# DRB CASE ACTION LOG

DRB Application No.: 05 01474 Project # 1002051  
 Project Name: Ohamsa Pledge  
 Agent: Sierra White Phone No.: 858-3100

**RE: Chamisa Ridge, Unit 2/final plat**

**DRB CASE NO/PROJECT NO: 1002051**

8414-D JEFFERSON ST., N.E. PHONE 505 856 5700
ALBUQUERQUE, NEW MEXICO 87113 FAX 505 856 7900

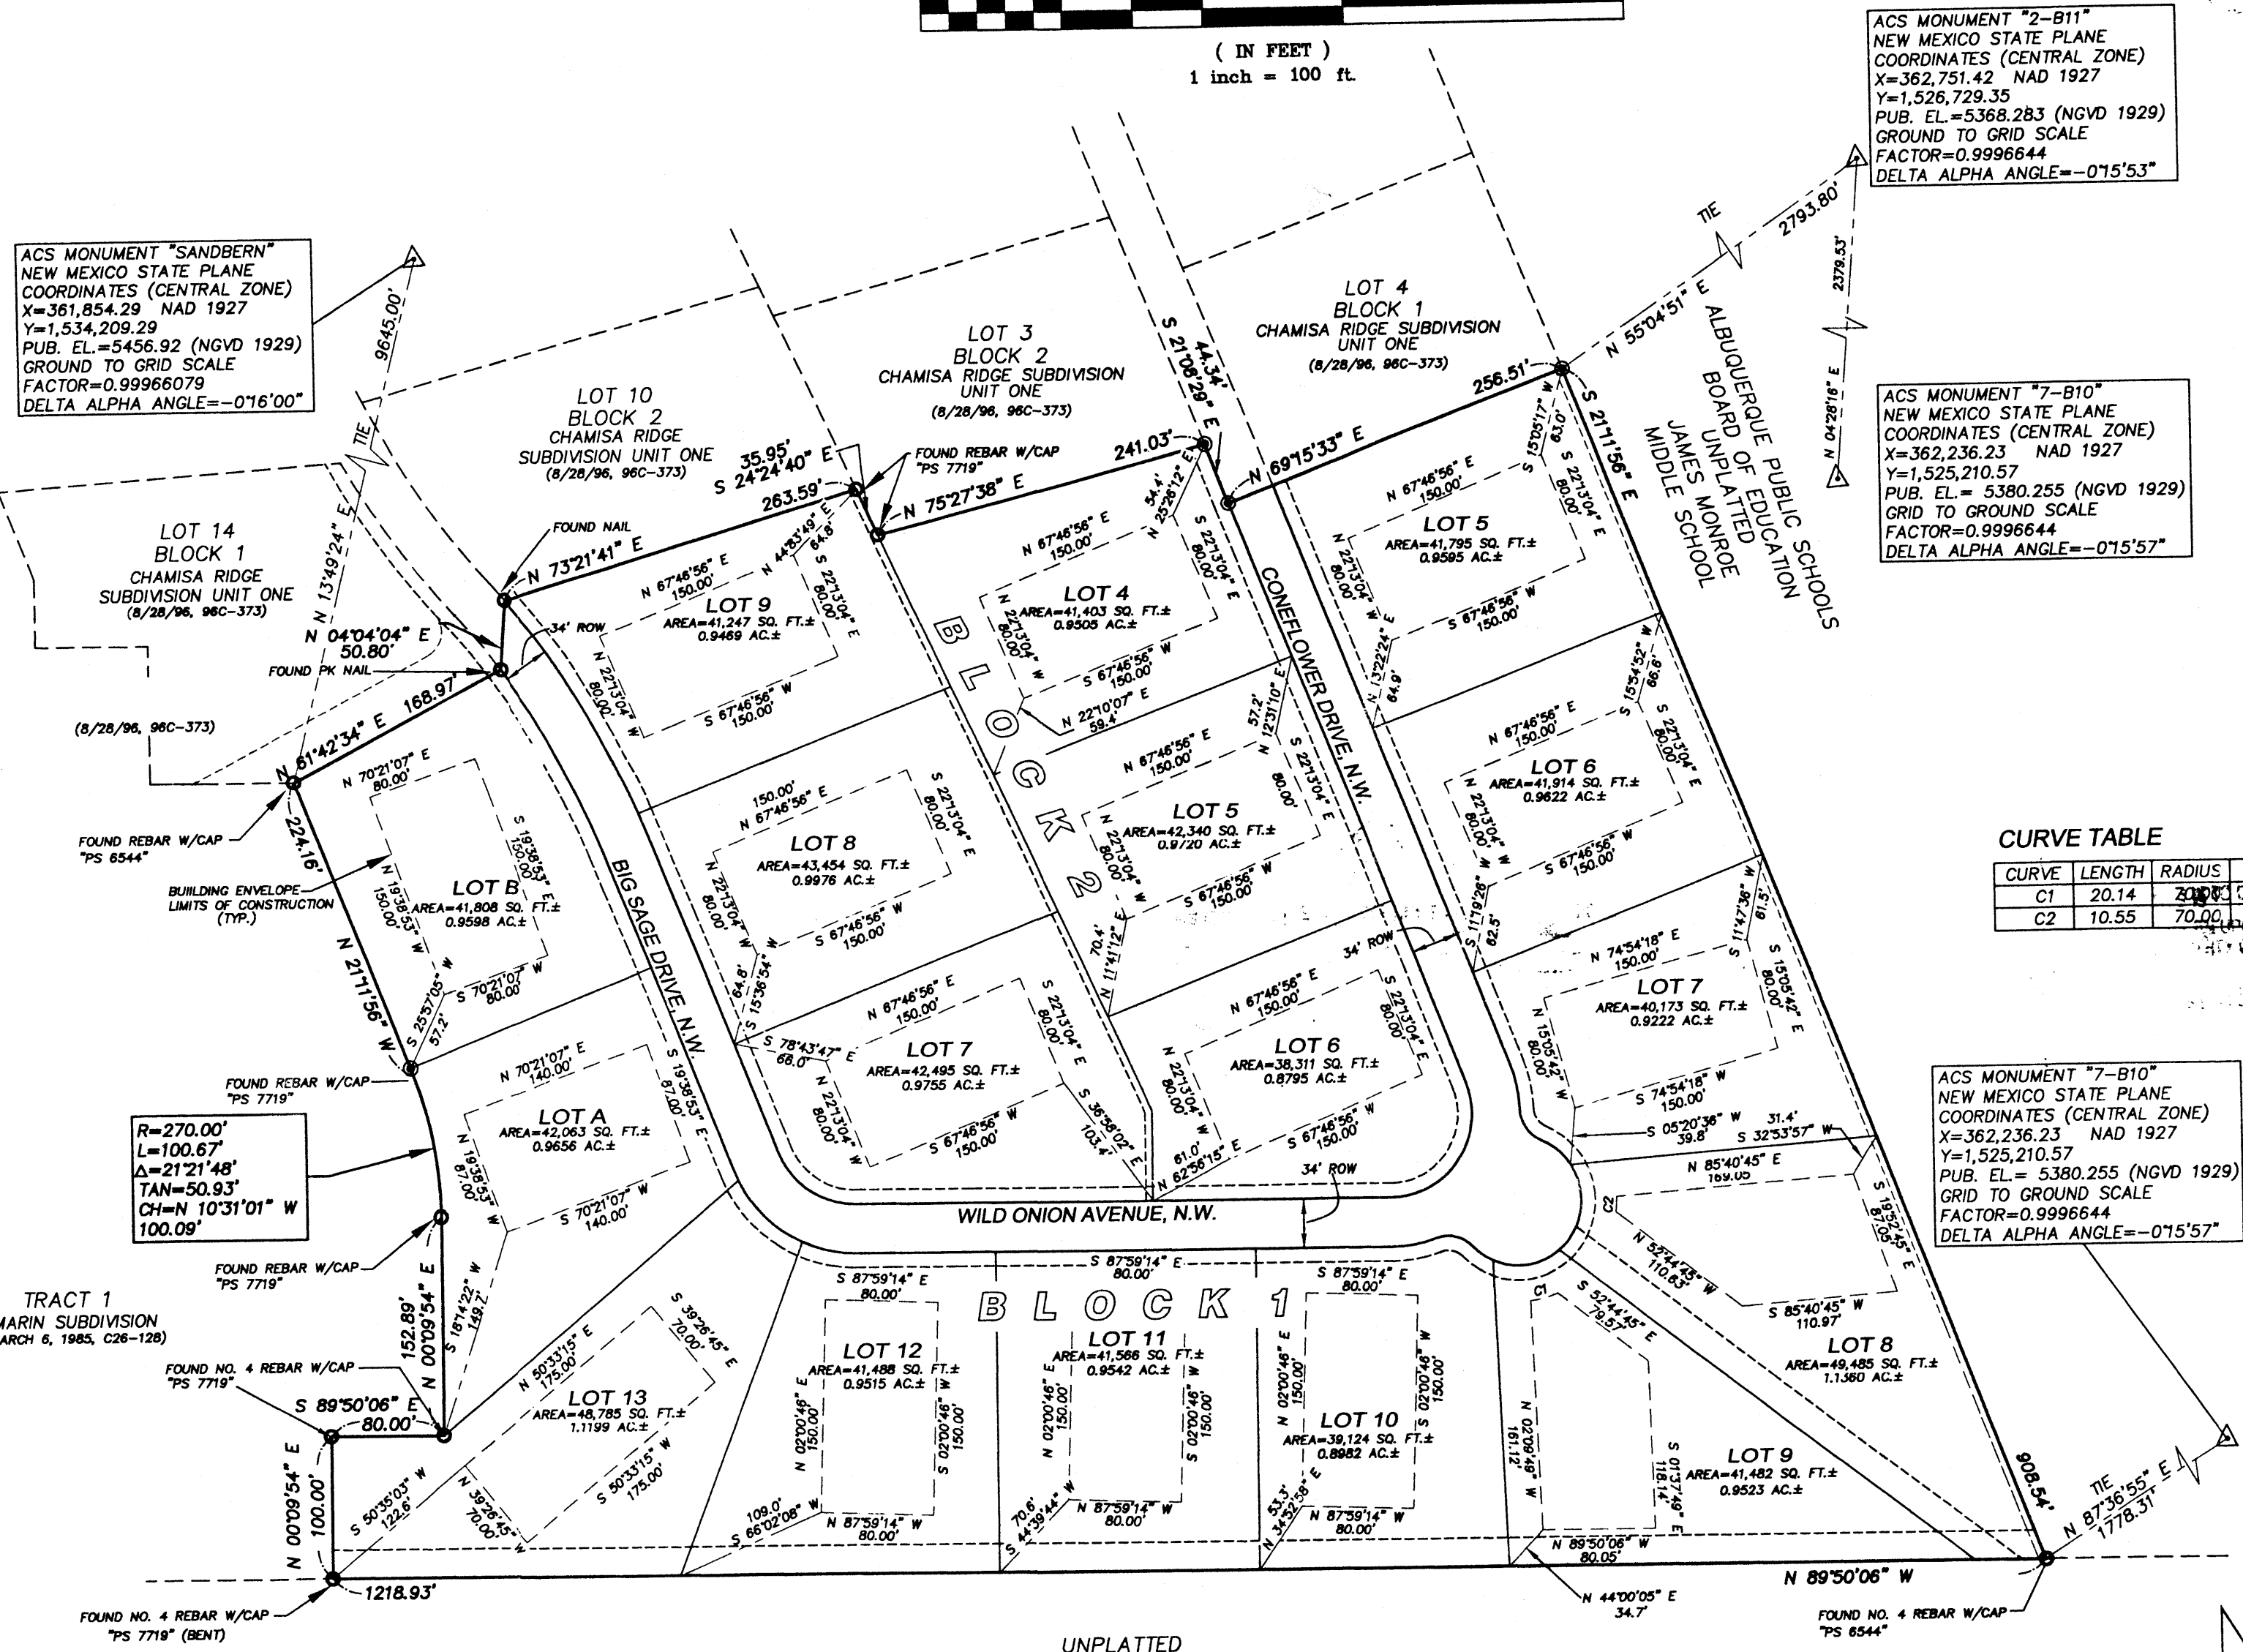
CITY ENGINEER / AMAFCA: AMAFCA sig  
 NMUE sig  
 call put esmt MGB  
 Pub. ded. to COA

AMAFCA must sign plat.  
Public drainage easements should be dedicated to City.  
Private drainage easements should state maintenance and beneficiary responsibilities.

Preliminary Plat of
Chamisa Ridge, Unit 2
Albuquerque, Bernalillo County, New Mexico
October 2003

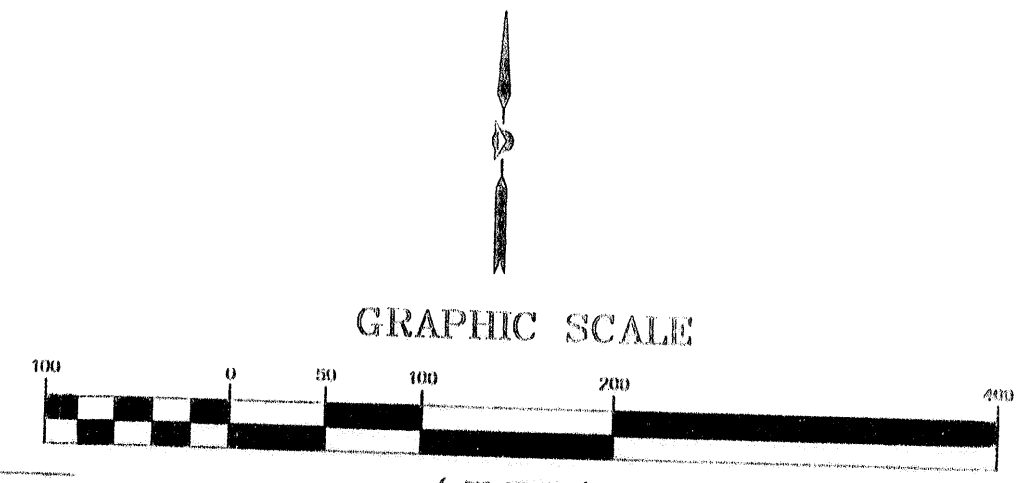
It appears that any kids will be playing in the street where there are no sidewalks. This street is very long for sidewalk on only one side of the street.
